CITY OF ALBUQUERQUE

Re: Juan Tabo Hills Unit 3A Grading and Drainage Plan
Engineer's Stamp dated 7-31-12 (M22/D015)

Based upon the information provided in your submittal received 8-2-12, the above referenced plan cannot be approved for Preliminary Plat action by the DRB until the following comments are addressed:

JUAN TABO HILLS UNIT - 3A
GRADING & DRAINAGE PLAN

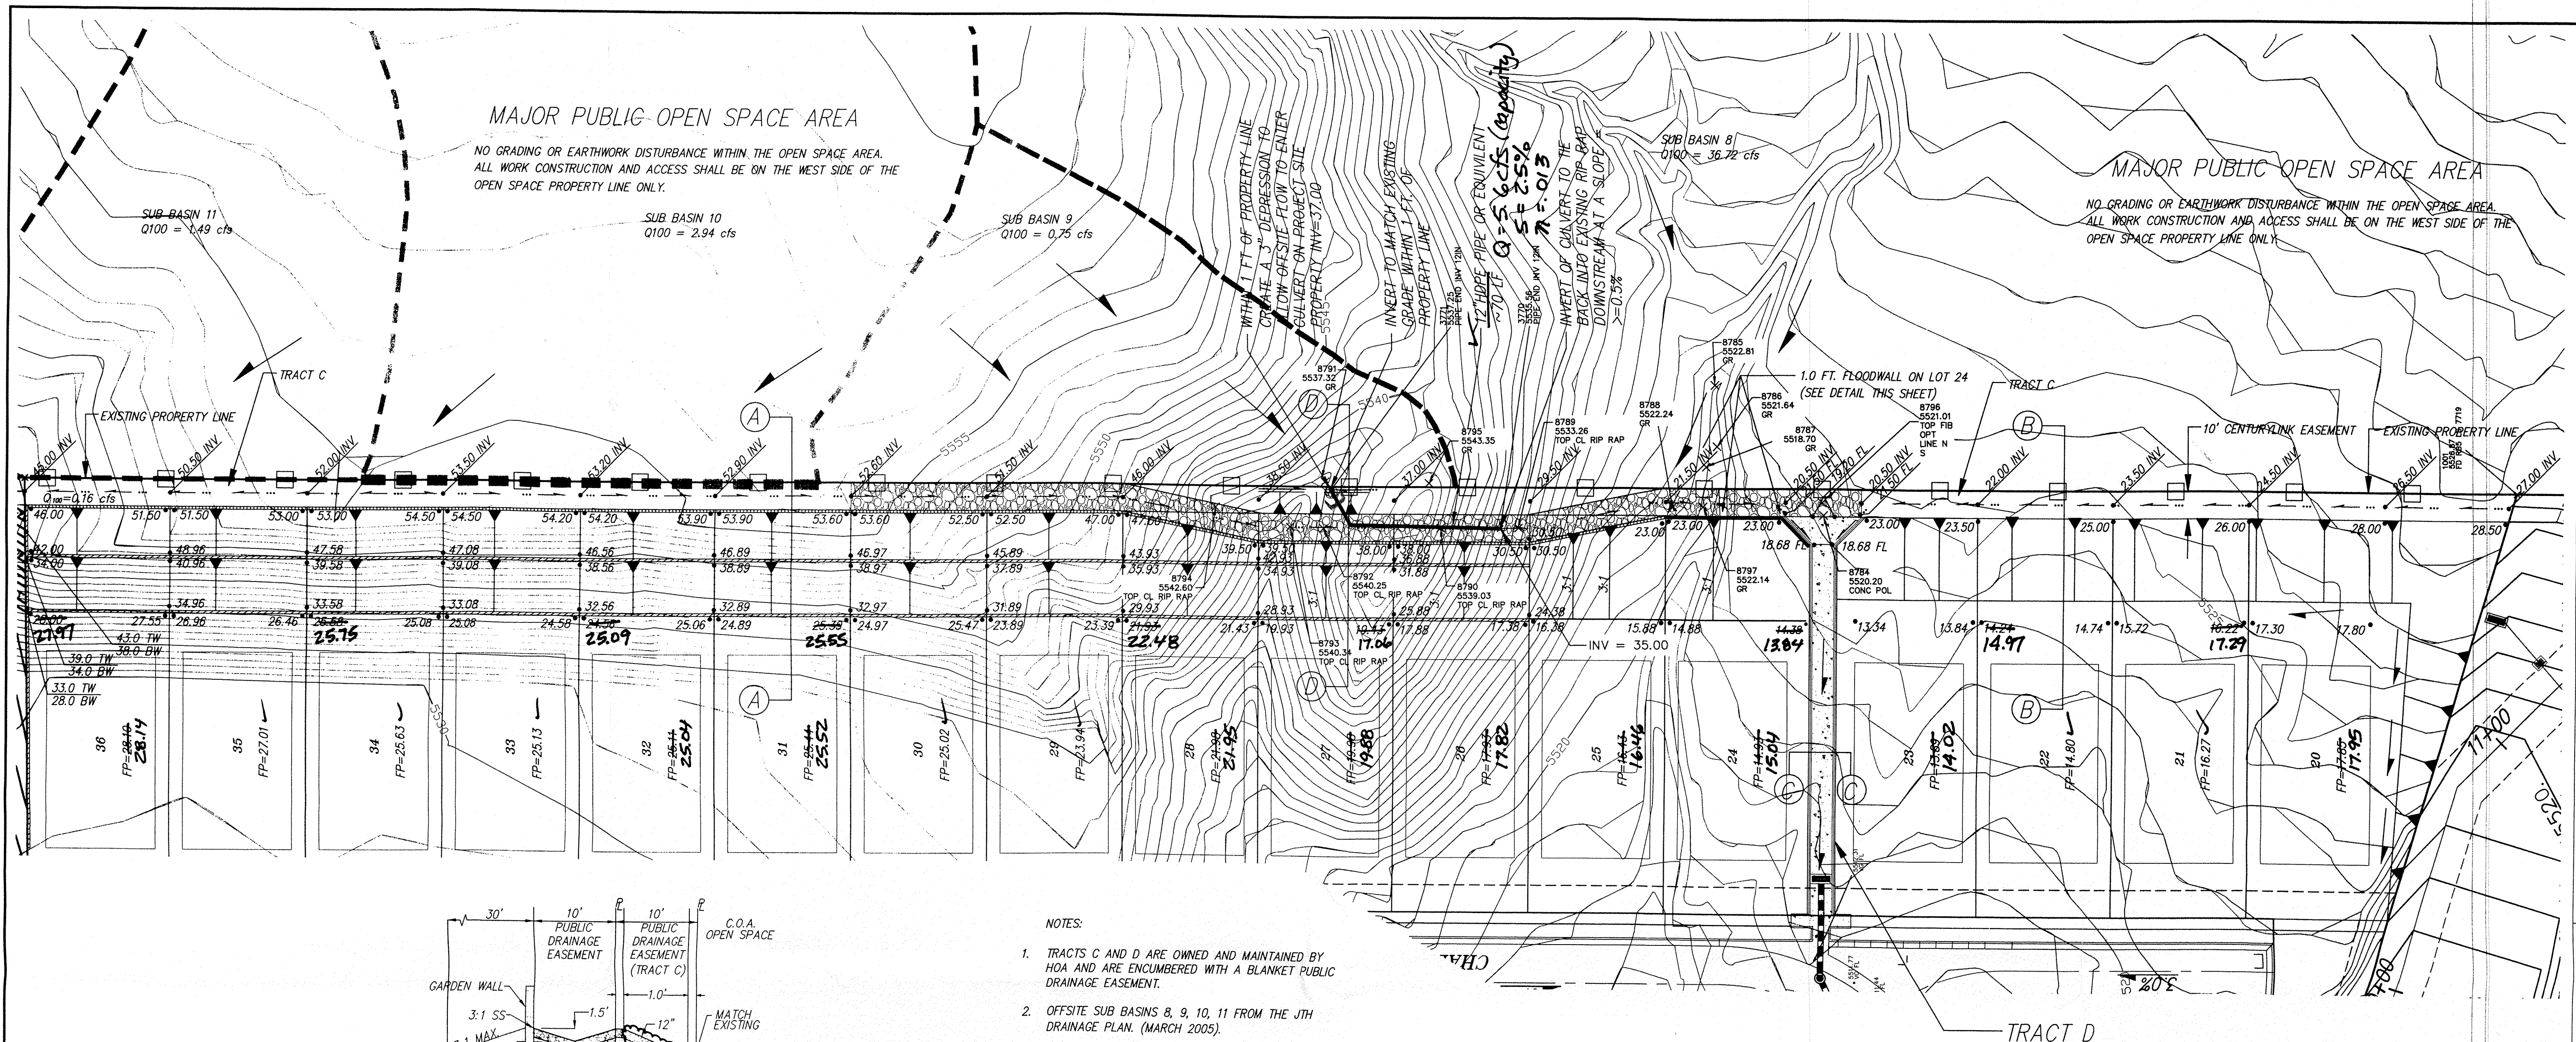
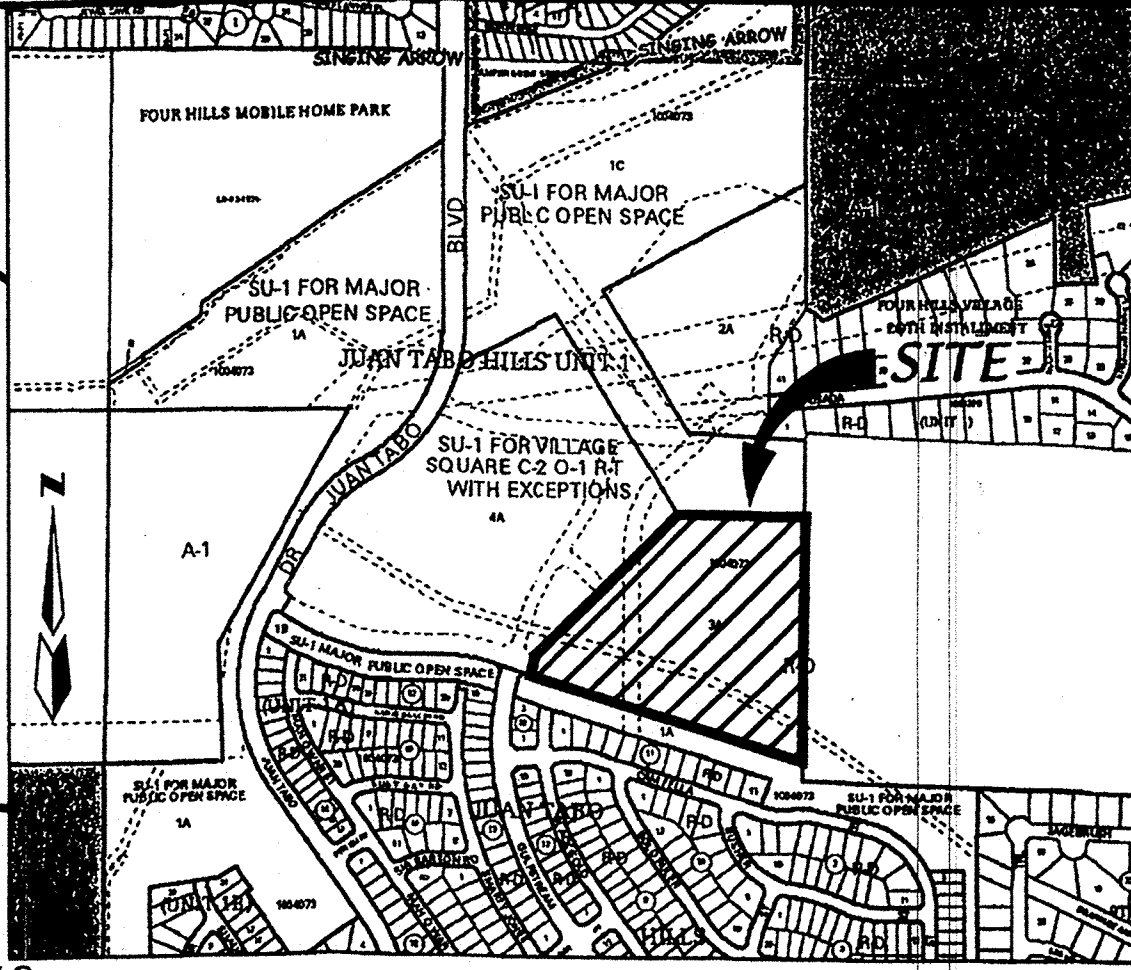
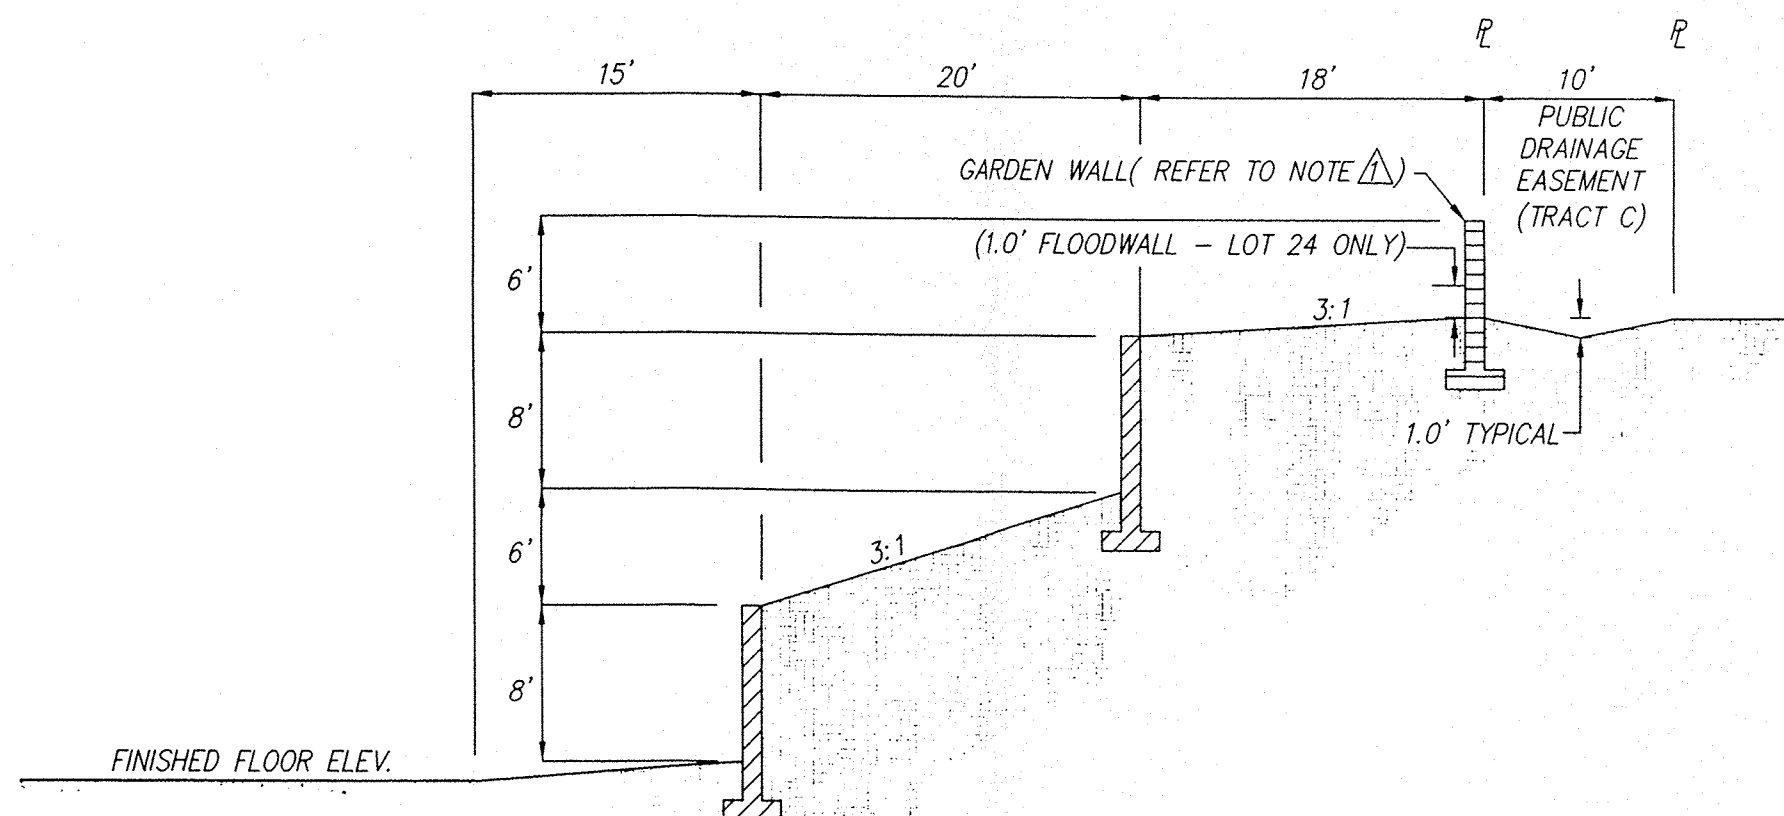
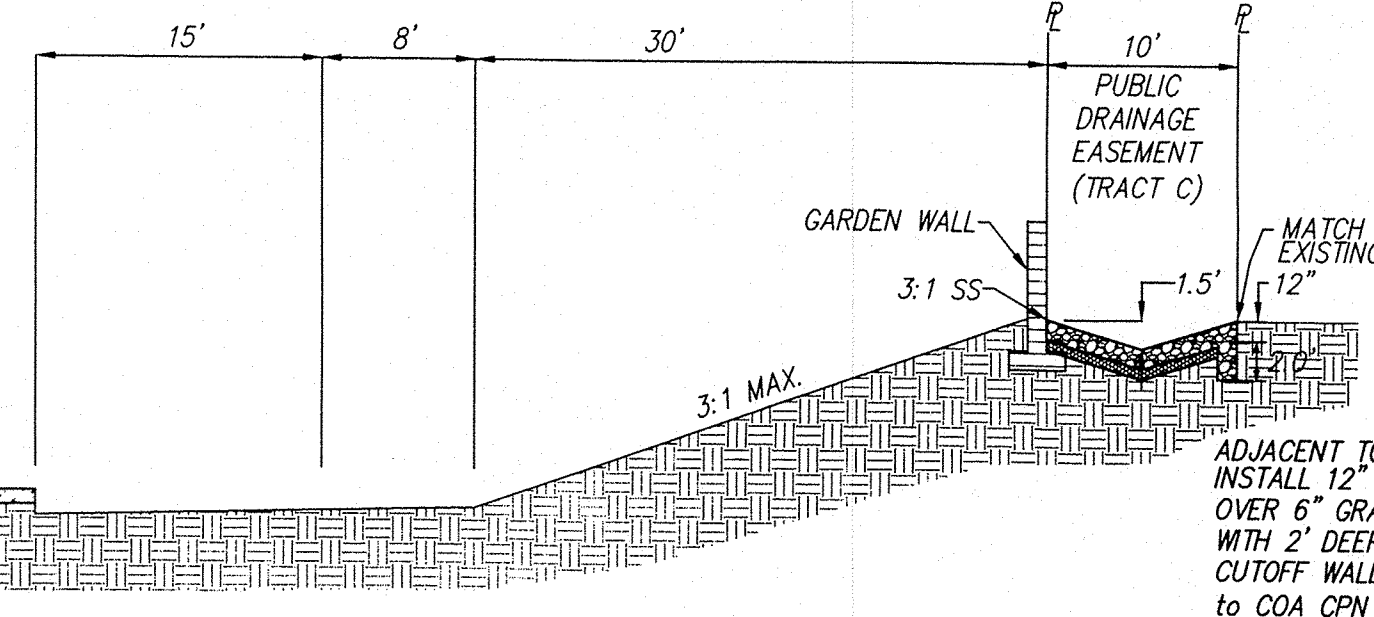
- As previously requested, provide existing and proposed grades west of Gulf Stream Dr. This will help in the determination of slopes next to the road. The grades should be continuous from the east side to the west side of Gulf Stream Rd. It is not preferred to show the building footprints near Gulf Stream Rd as they do not exist and subtract from the clarity on the plan in this area.
- Proposed grades along the northern edge of the site will require a retaining wall in excess of the 8 foot zoning requirement. Pad grades may have to be changed to reduce the grade difference between the Open Space tract and this development. This wall (and all walls) should be shown as retaining wherever there is a proposed grade change of 2 feet or more.
- Please add a build note for the rip-rap in Tract C.
